# CITY OF ALBUQUERQUE

**RE: Sunset Gardens Subdivision (File: K12D003)**  
**Drainage Report, Engineer's Stamp Date 1-19-15**  
**Grading and Drainage Plan, Engineer's Stamp Date 5-15-15**  
**Superseded by Grading and Drainage Plan, Engineer's Stamp Date 6-23-15**

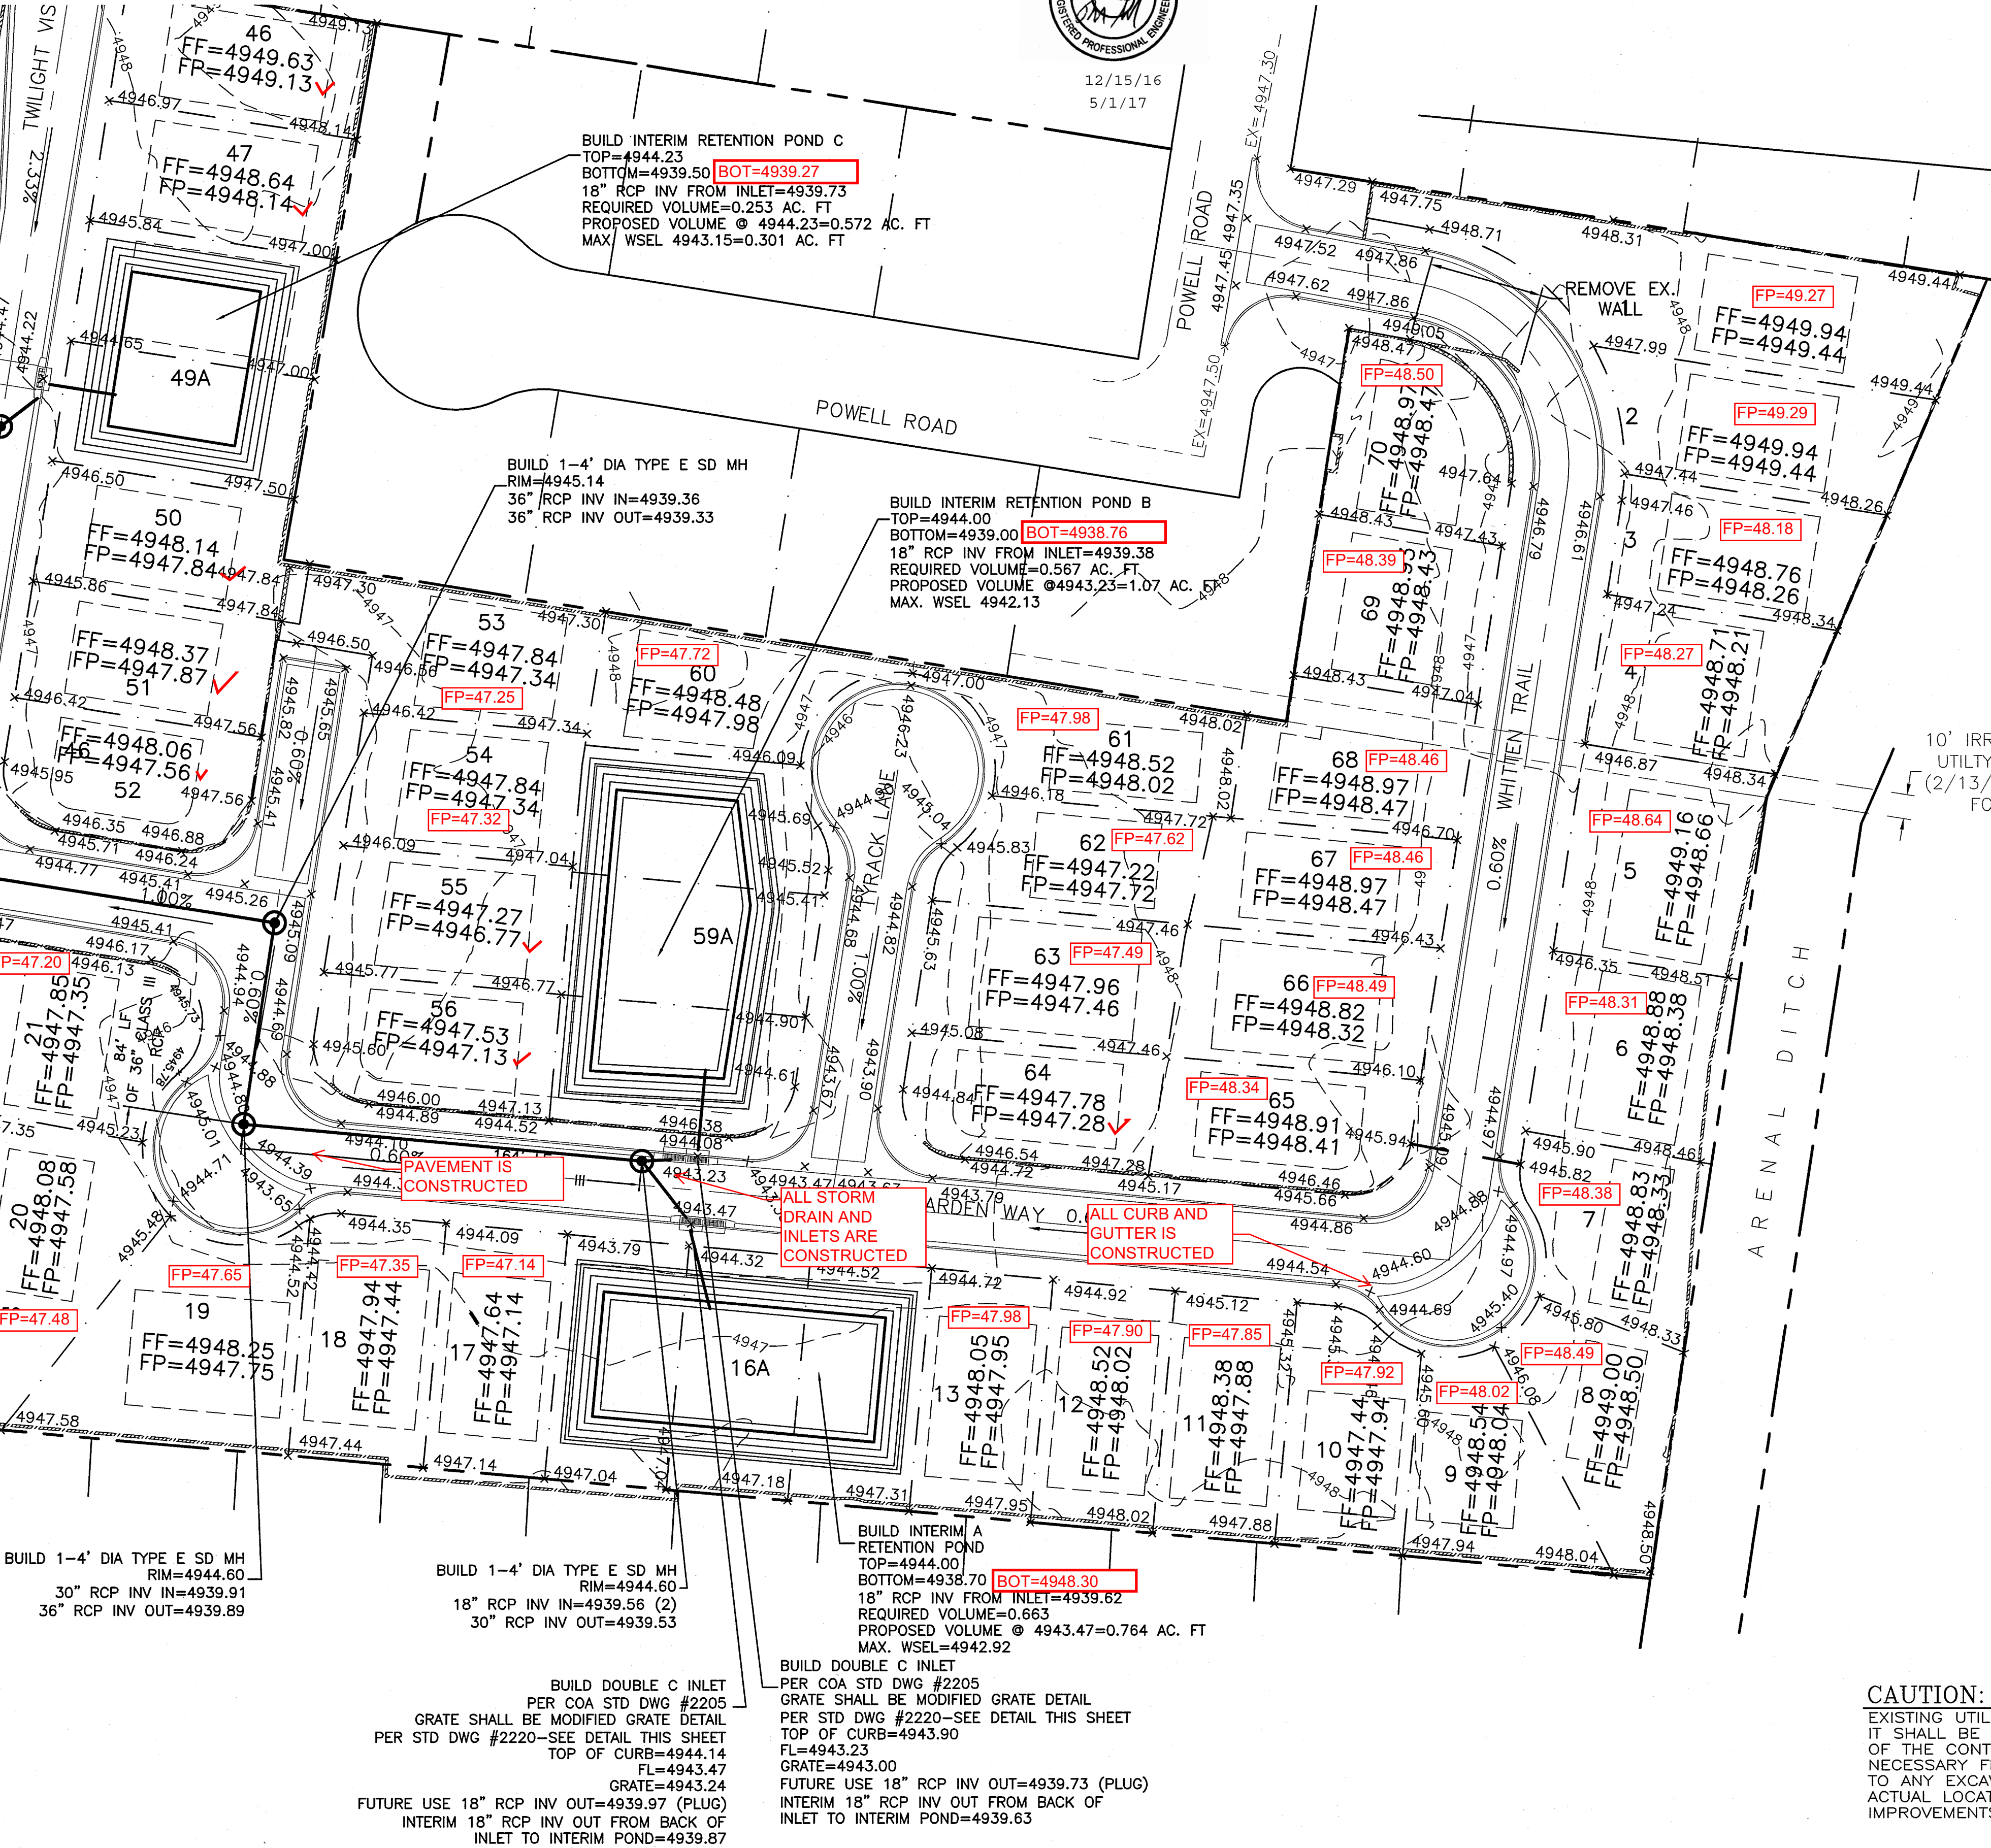
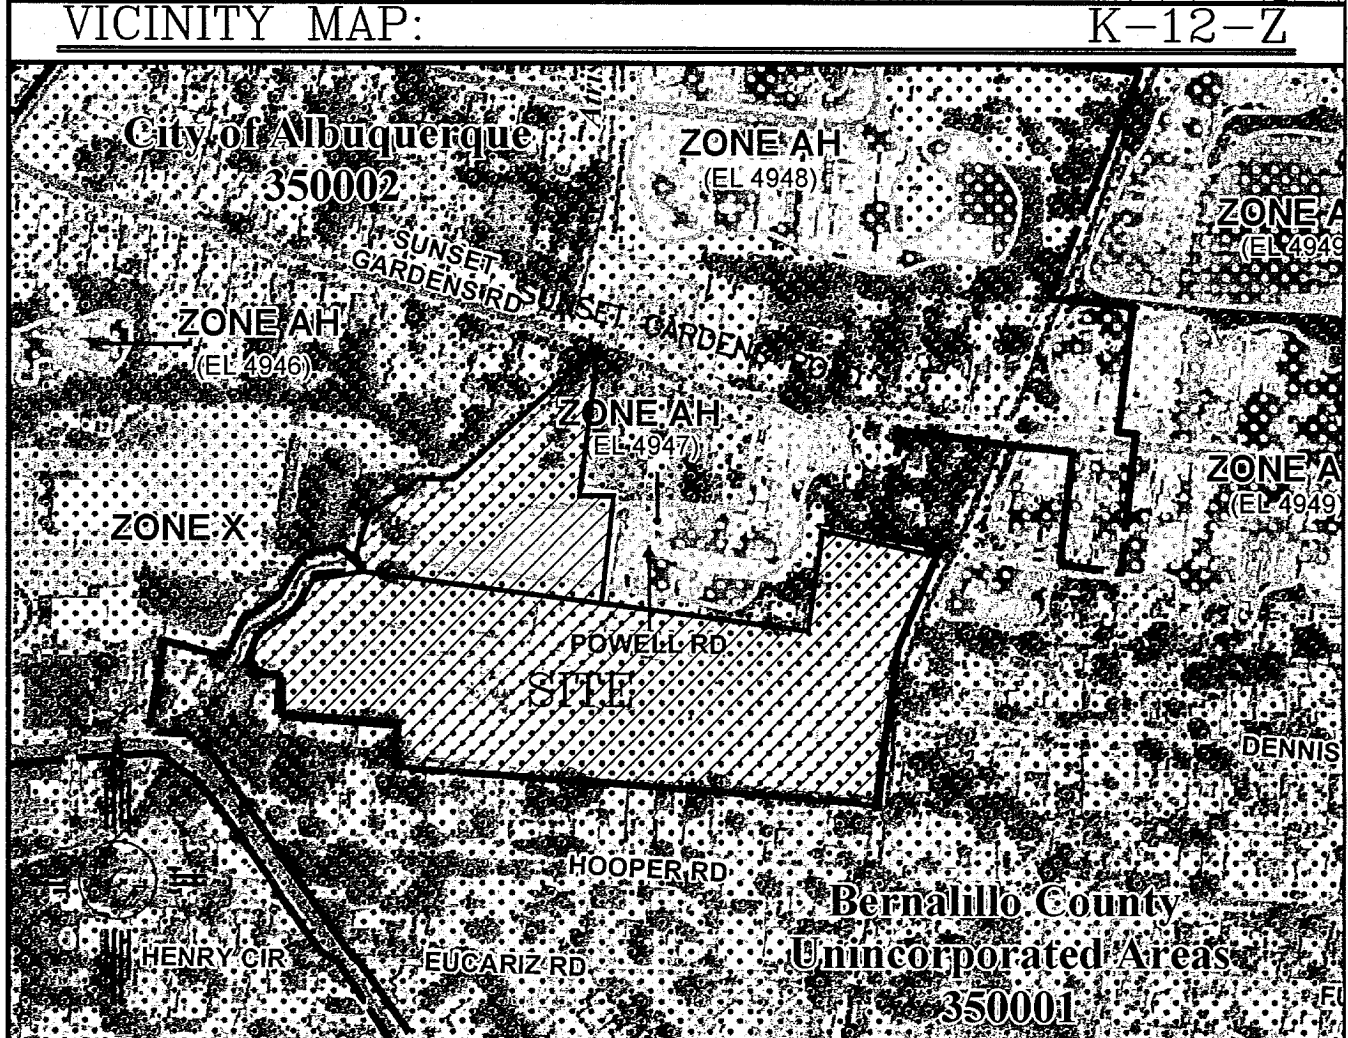
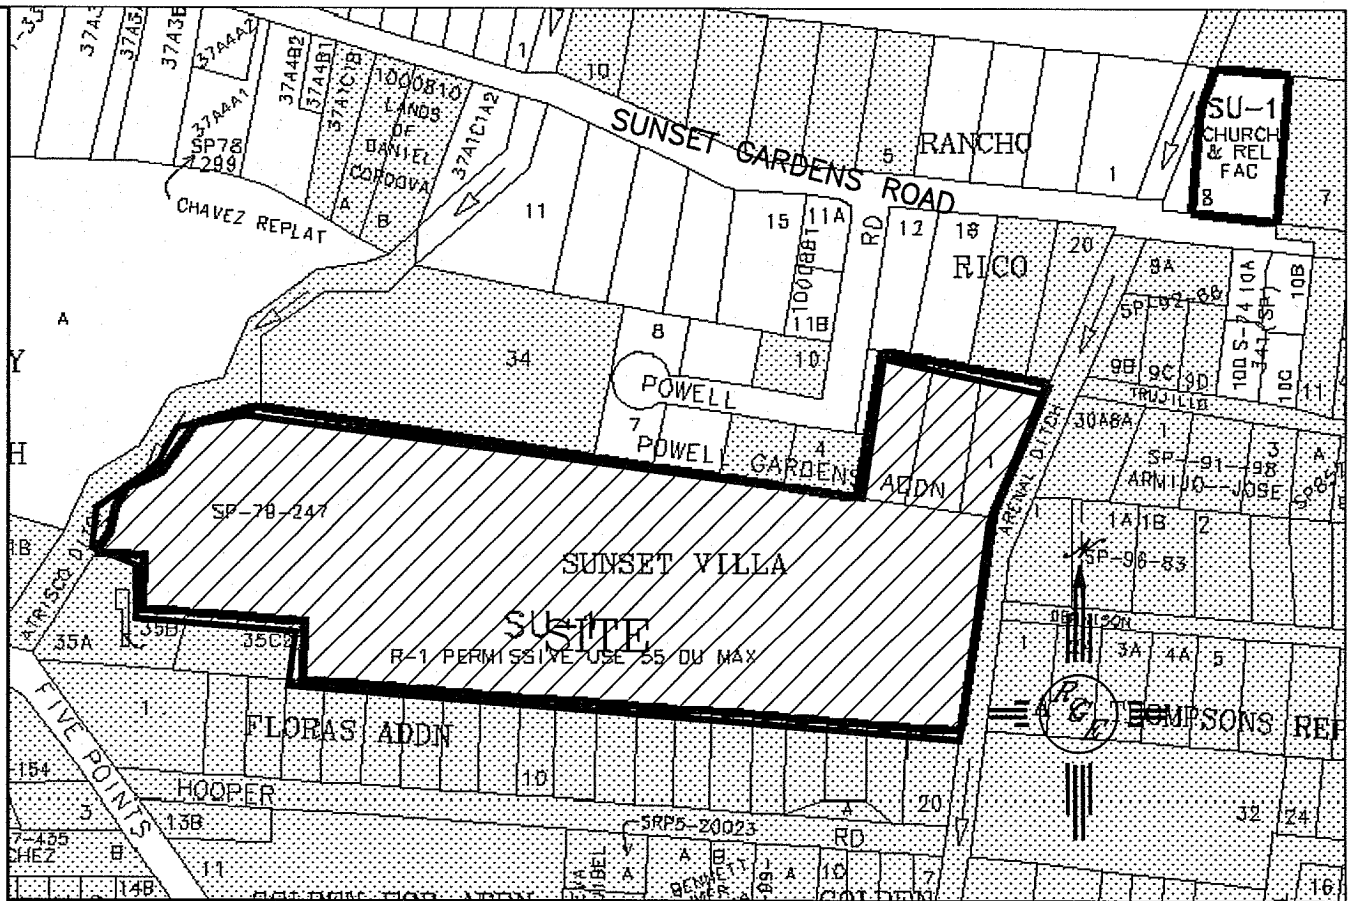
1. Correct the Lot numbers to match the plat, particularly Lots 46-52
2. G&D dated 6-23-15 does not have existing contour labels (older submittal does)
3. Correct the BFE Elevation (FIRM says 4947)

4. Label and Correct all the SD pipe sizes along Garden Way. Series should be 30", 36", 36", and 30".
5. Show and Label the irrigation and 10' utility easement thru Lots 68 and 5 ( not on 6-23-15 submittal- but is shown on the 5-15-15 submittal)

6. Specify the elevation of the turned block on wall along Lots 46-50 so that the BFE will equalize within the present flood zone boundary.
7. Legal Description, Benchmark, Datum are not shown on the plan (The property line along Tract A (the roadway tract) should be the same line type as the property line between lots.

8. Address "First Flush" with a statement. (it was on the 5-15-15 plan but not on the later one)
9. Show existing flow line elevations in Powell where new construction ties to existing. (show also on Work Order)

10. It is noted that the Emergency Spillway for each pond is the inlet grate. Do you mean that the pond will surge back to the inlet?
11. Wall hatching is inconsistent with legend. Also, some walls not hatched at all, but only on the latest submittal.

12. Inlets into all the Ponds: (shown also on Work Order)
  - a. the invert at pond is higher than invert at inlet
  - b. the Top of Curb is 1.43' higher than the grate elevation for Ponds A,B

- c. The Grate Elevations shown are the Flowline elevations

13. Invert elevations of the 18" dia. into pond is about 1.5' above the Max. allowed invert elevation per detail 2202, Note B. Invert is also higher than "future use" invert. Hydrology would prefer for the inverts into pond to be lower than the "future use inverts." When the inverts to the pond are plugged in the future, lean fill can be poured to slope the bottom of the inlet to the "future use" invert. A special detail will need to be on the work order and G&D plan. Provide the detail on the G&D for future reference.
14. The Pond elevations and capacities do not match that shown in the report
15. Max WSEL for the ponds indicate that there is not sufficient freeboard.
